Rezoning Transportation Analysis

Petition Number: 2022-159

Date	Description
02-23-23	First Review (JLP)

The petition is located on the north side of York Road, a State-maintained major throughfare west of Majestic Oak Drive, a State-maintained minor collector. A Traffic Impact Study (TIS) is not required for this site due to the site generating less than 2,500 trips. Site plan and/or conditional note revisions are needed to commit to installing a MUP along York Road in accordance with the Charlotte BIKES policy, install right turn lane on York Road at the proposed site access, and including the CDOT standard notes. Further details are listed below.

SCHEMATIC SITE PLAN

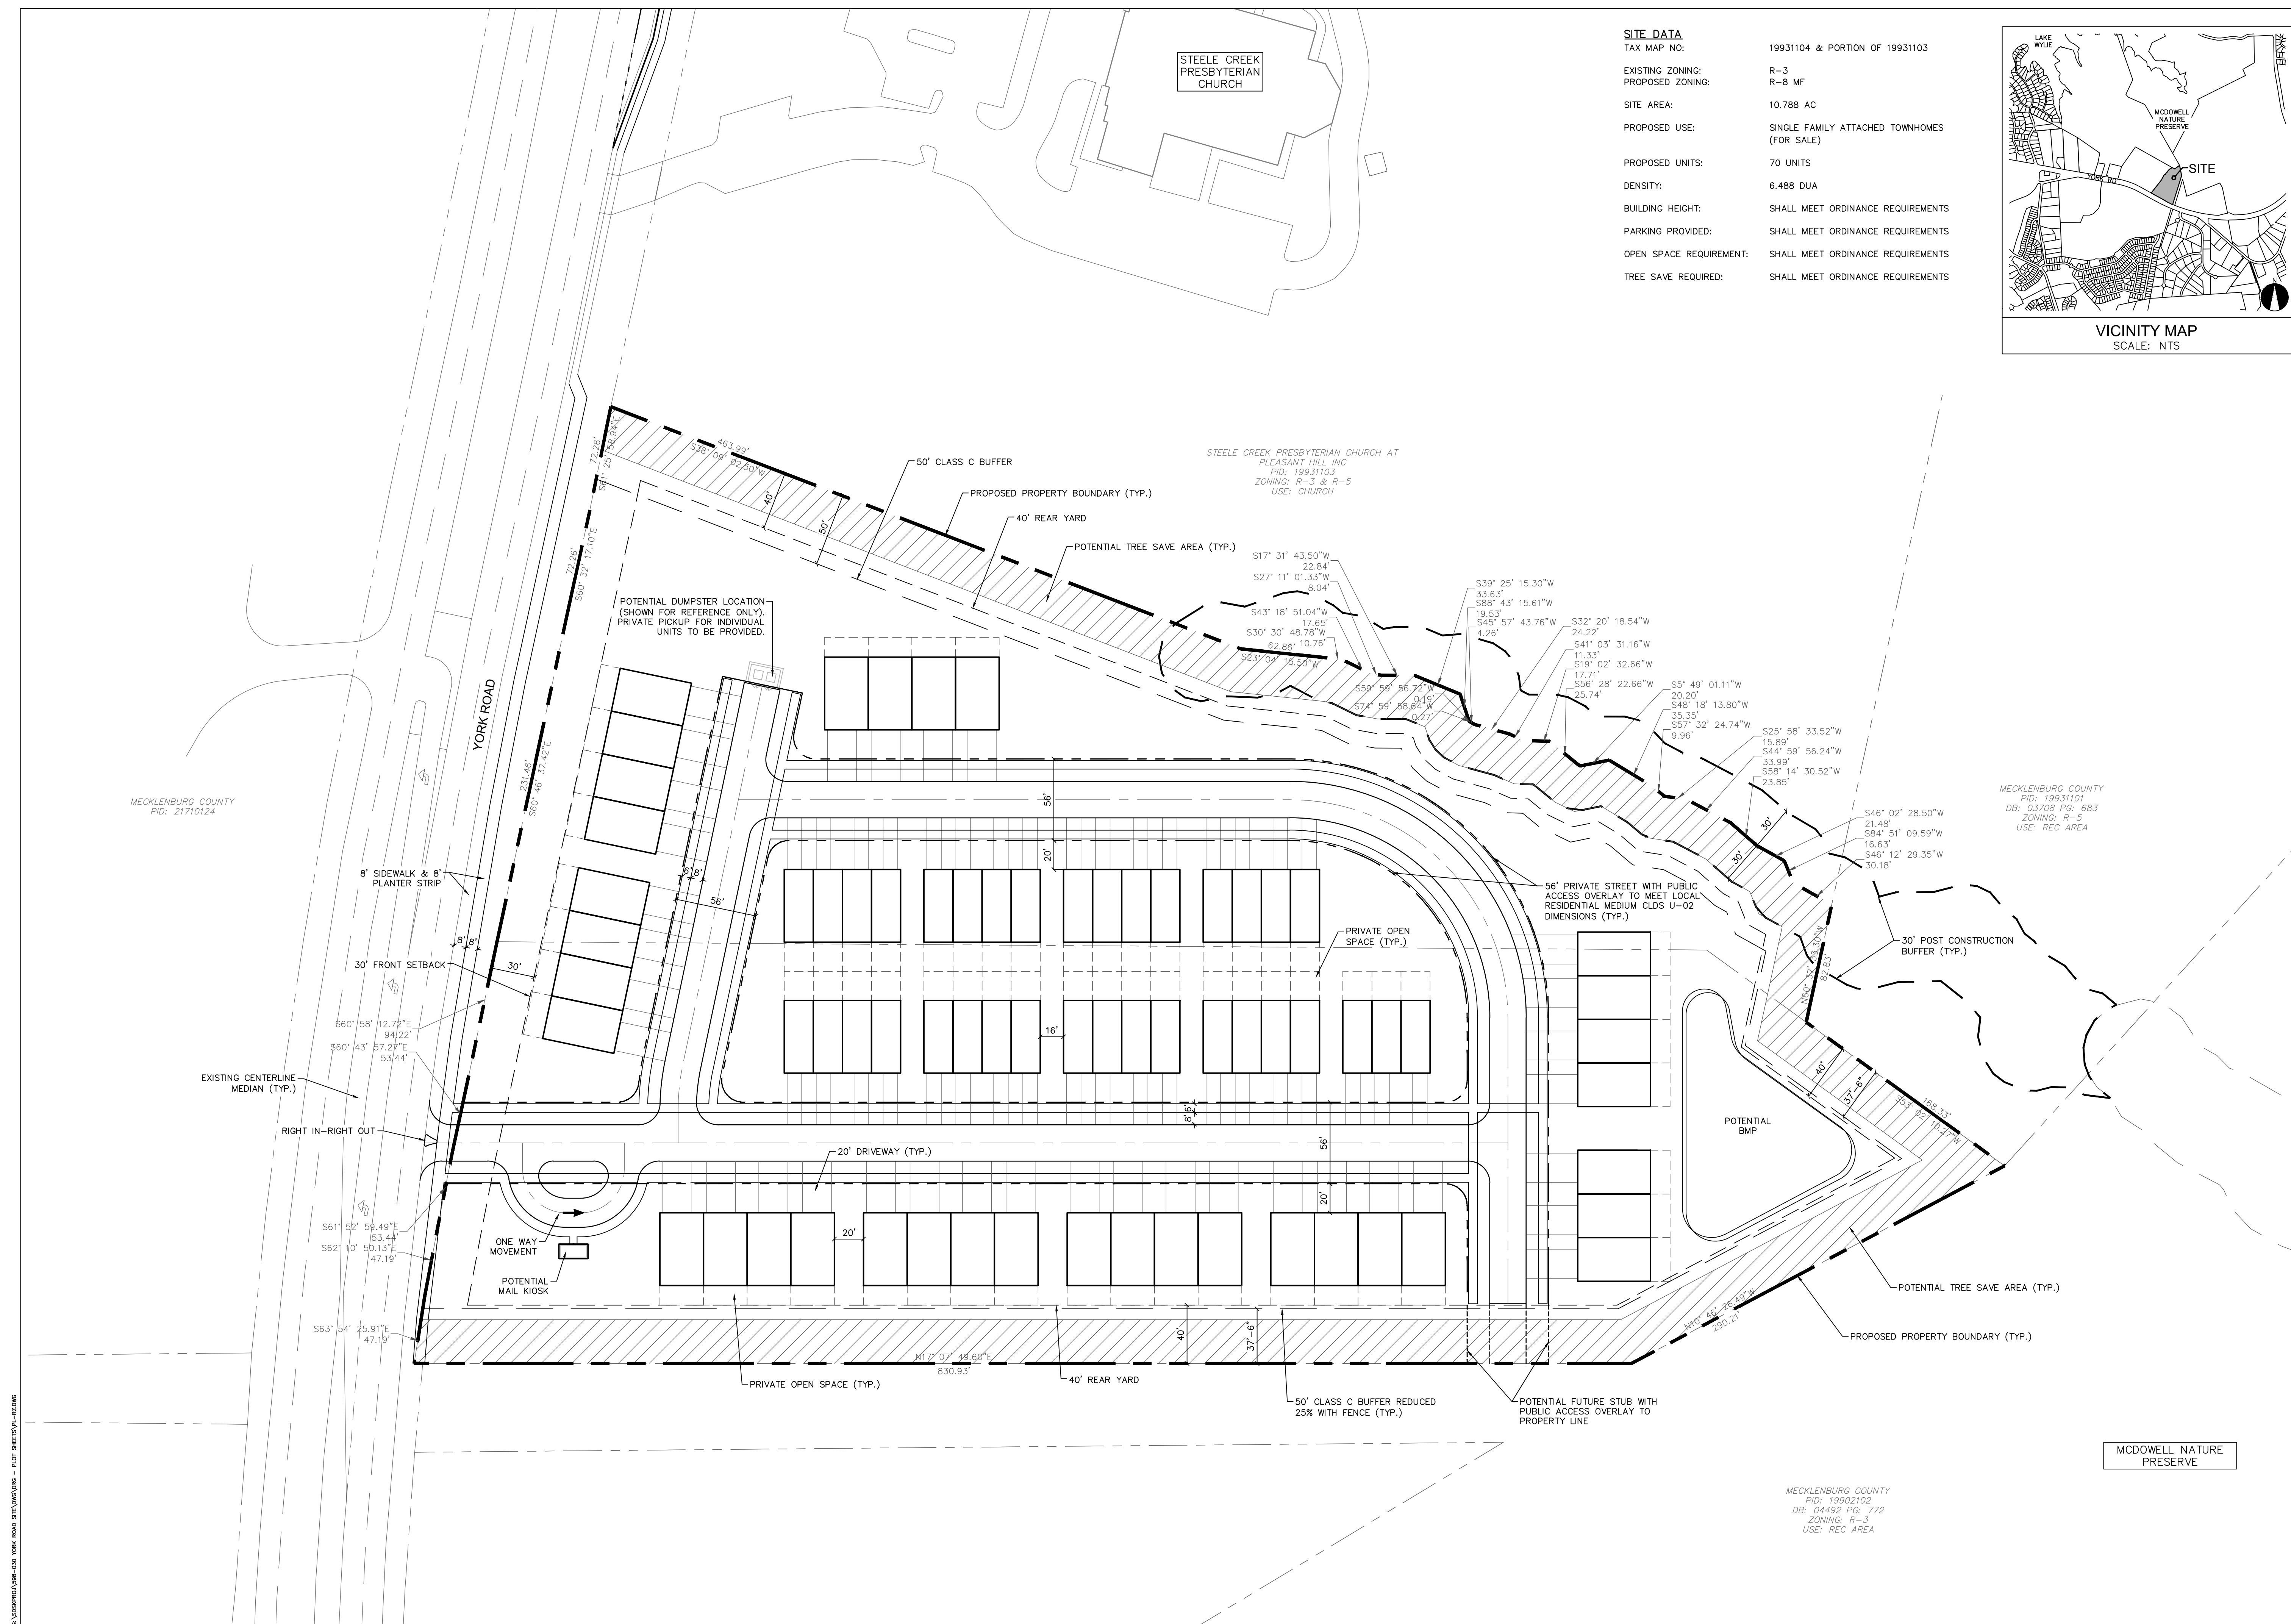
- York Road:** Location of the future curb and gutter to be installed at 33 feet from roadway centerline to accommodate the Charlotte Streets Map roadway typical section of four lane avenue with shared use path. The future curb and gutter should be shown on the plan and dimensioned from the centerline.

Label and dimension the curb and gutter from the centerline for each road on the site plan.

- Revise site plan and conditional note(s) to commit to dedicate 50' right-of-way from the road centerline along York Road. The site plan shall label and dimension the right-of-way from the road centerline.
- Revise site plan to callout all internal streets as private roads with public access easements.
- Revise site plan to remove the stub to the adjacent park property. If required by Subdivision the stub should be provided to the property to the west and not the park property.

6. Revise site plan and conditional note(s) to commit to construct bicycle facilities by installing a 8' planting strip and 12' multi-use path to meet the Council-adopted Charlotte BIKES Policy. Multi-use paths maintained by the City shall meet ADA/PROWAG requirements.
7. Per coordination with NCDOT, revise site plan and conditional note(s) to commit to installing a right turn lane into the site off York Road with the appropriate taper and storage.
8. Per coordination with NCDOT, revise site plan to provide a 100ft protected driveway stem measured from the ROW. The mail kiosk and turnaround shall be relocated outside of the protected stem.

11. If site is to remain in the ETJ: Revise site plan and conditional note(s) to construct 8-foot planting strips and 12-foot multi-use paths on York Road. The site plan shall label and dimension both items from the back of curb and gutter or edge of pavement. Add conditional note that the entire facility must be outside of the right of way and within a public access easement. Add conditional note committing to construction and maintenance of the 12-foot multi-use path on York Road.
